**SUBJECT: Grandview Reserve Filing No. 1**  
**SF\_Final Plat (SF-22-XXX) – Letter of Intent**  
**SF-23-011**

This Letter of Intent (LOI) is being submitted as part of the Final Plat Review (SF-22-XXX) application for Grandview Reserve Filing No. 1 on behalf of 4 Site Investments, LLC.

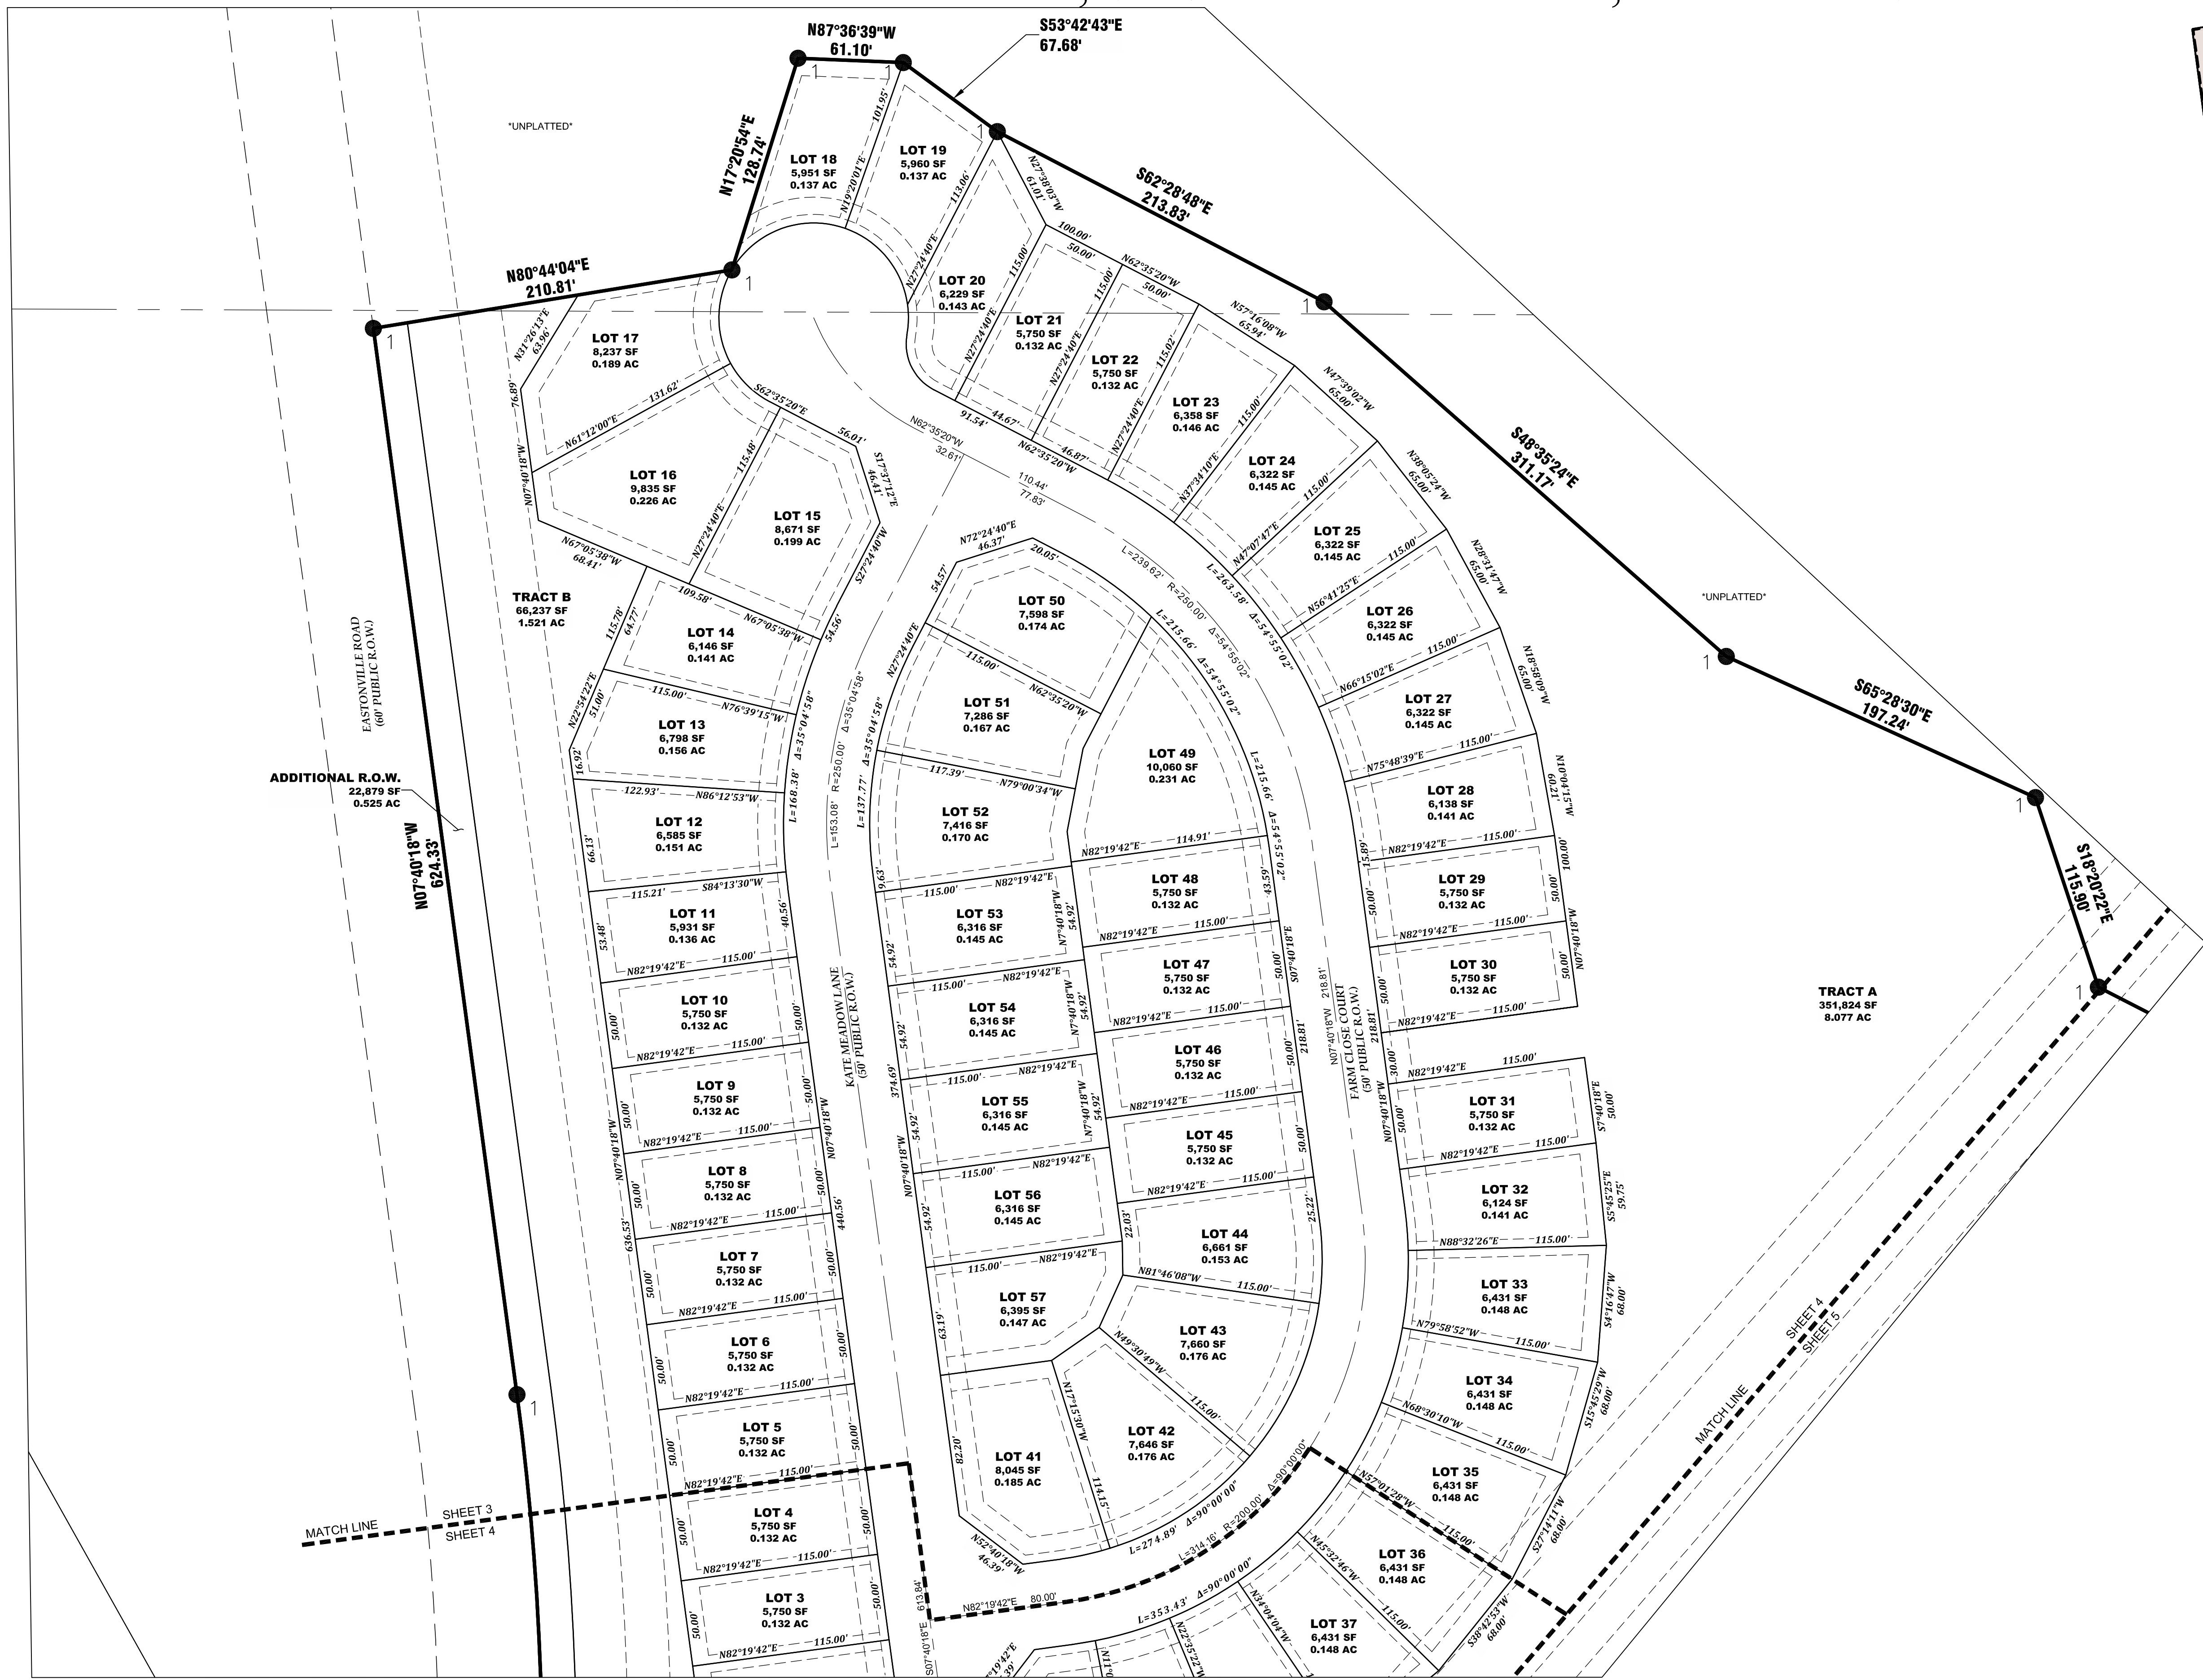
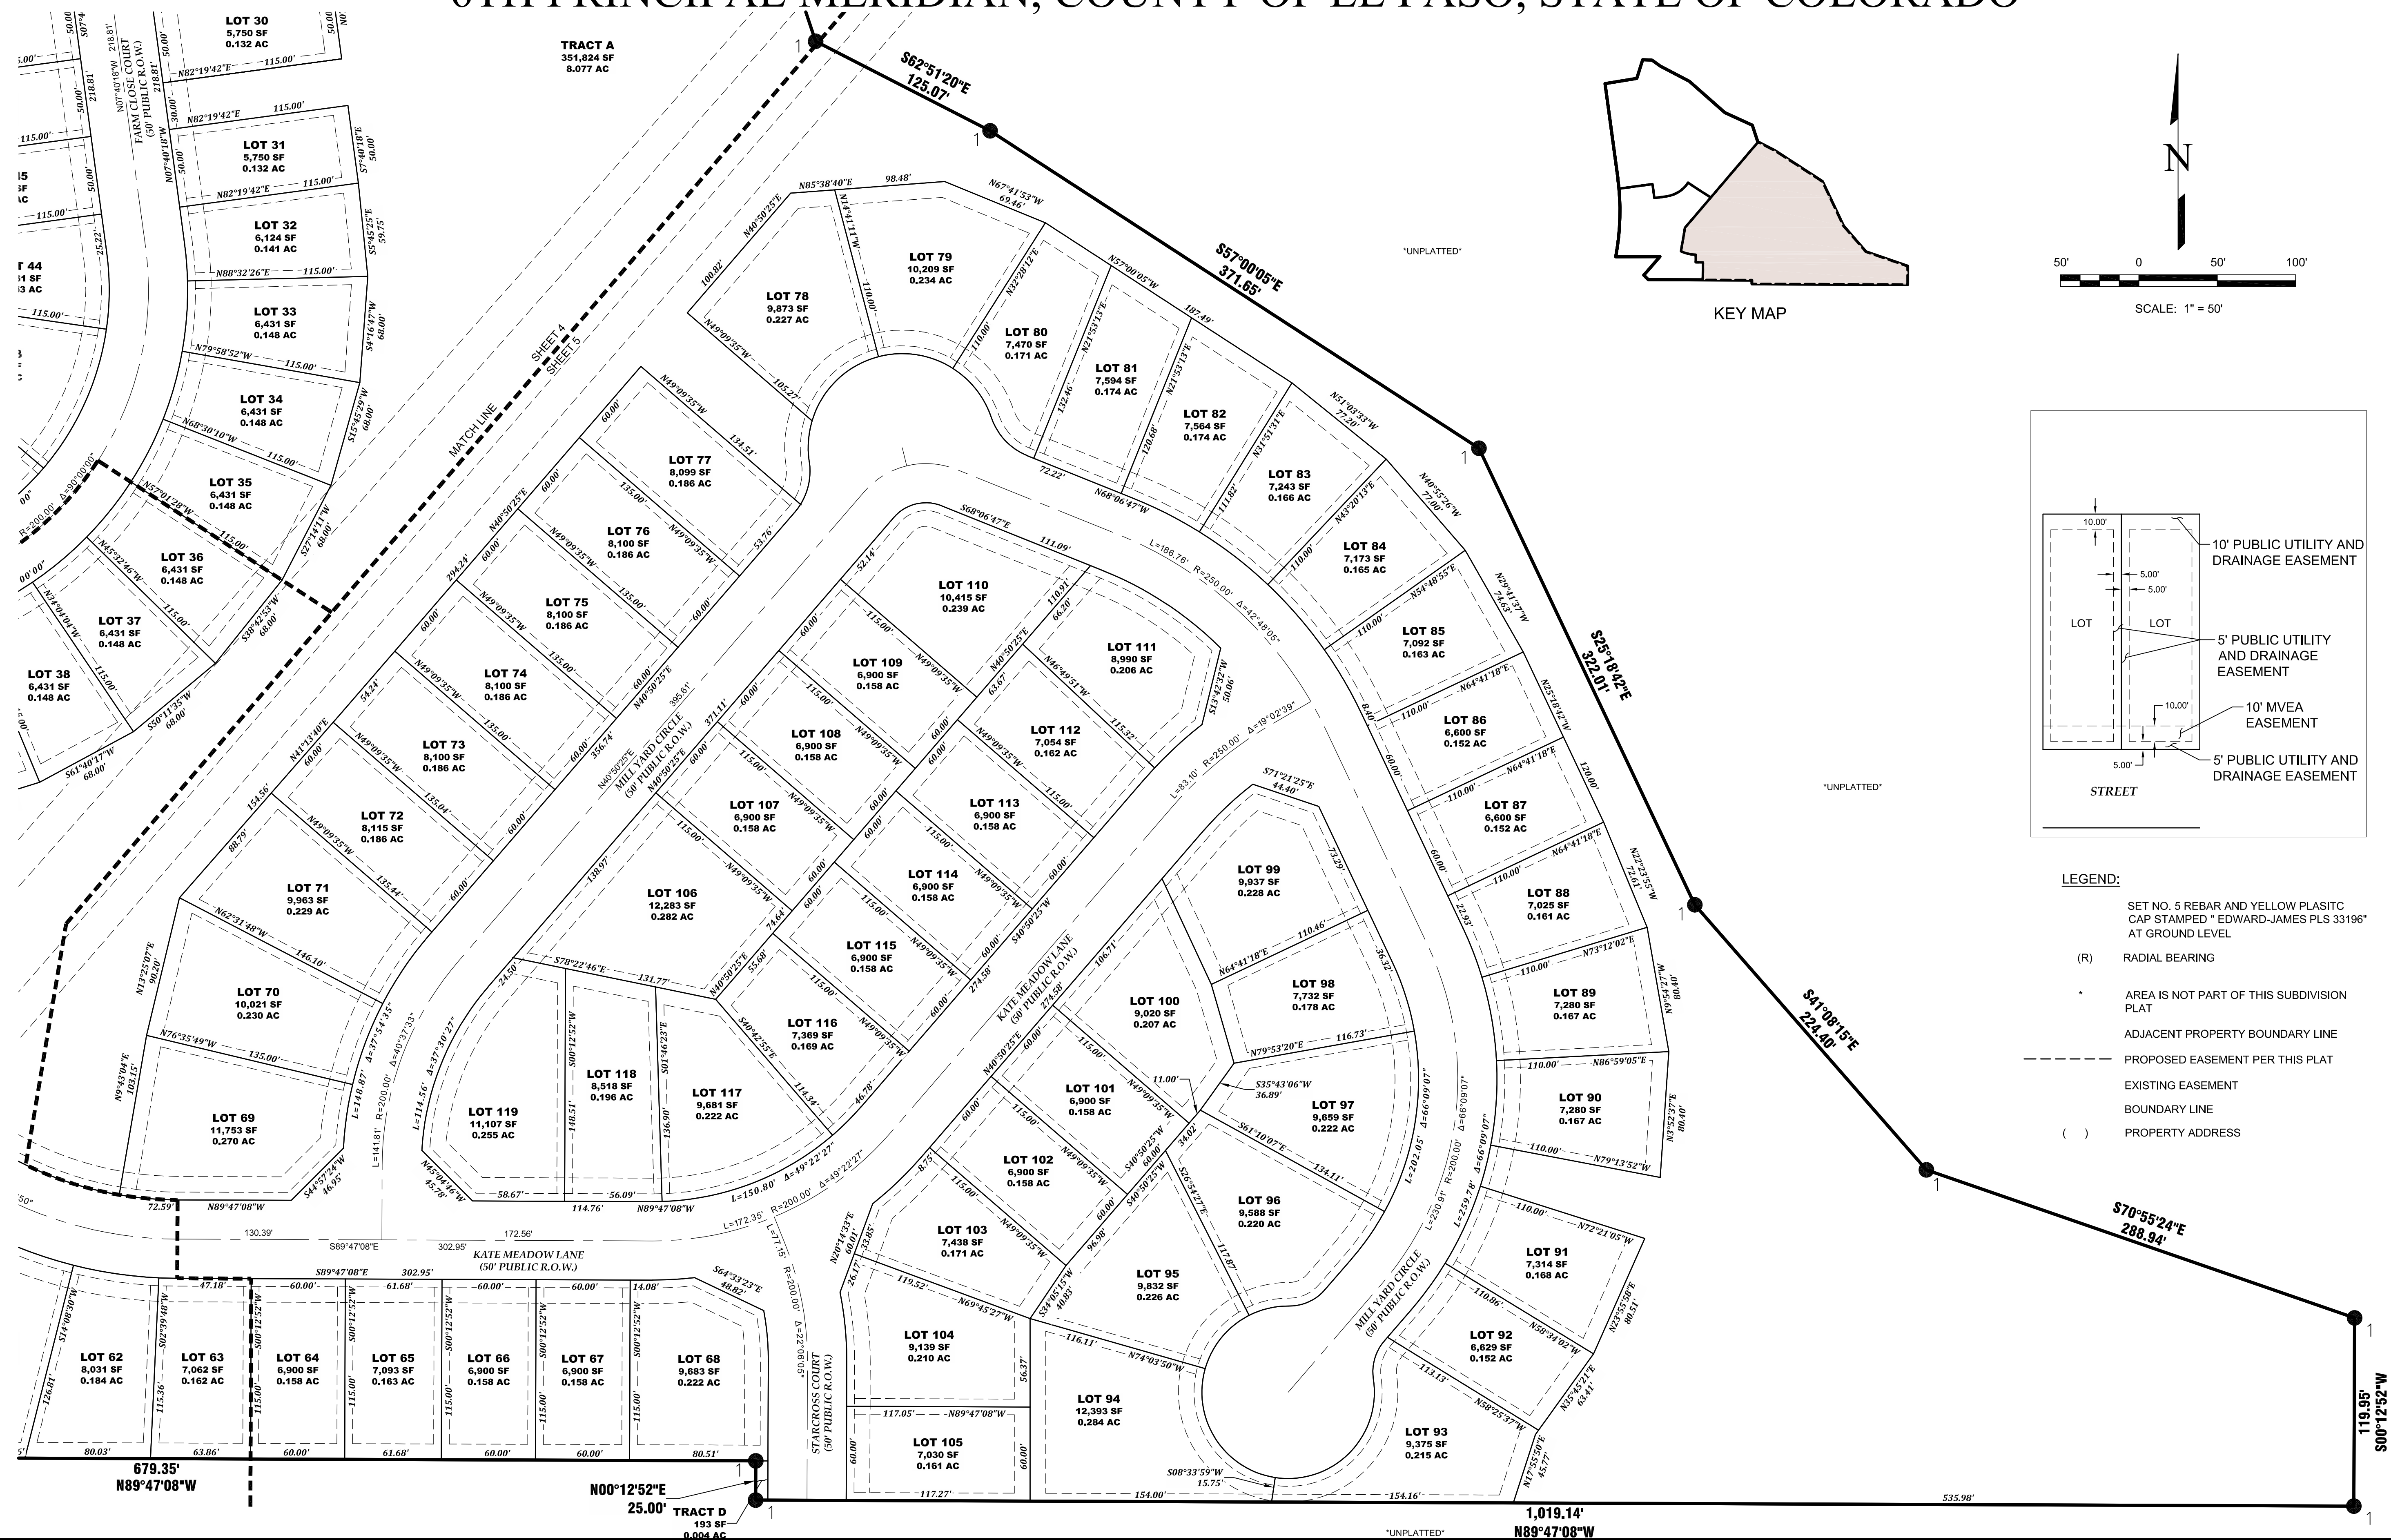
now is the time; this is the last step to entitling lots for sale; depict a plat note with no basements for certain lots
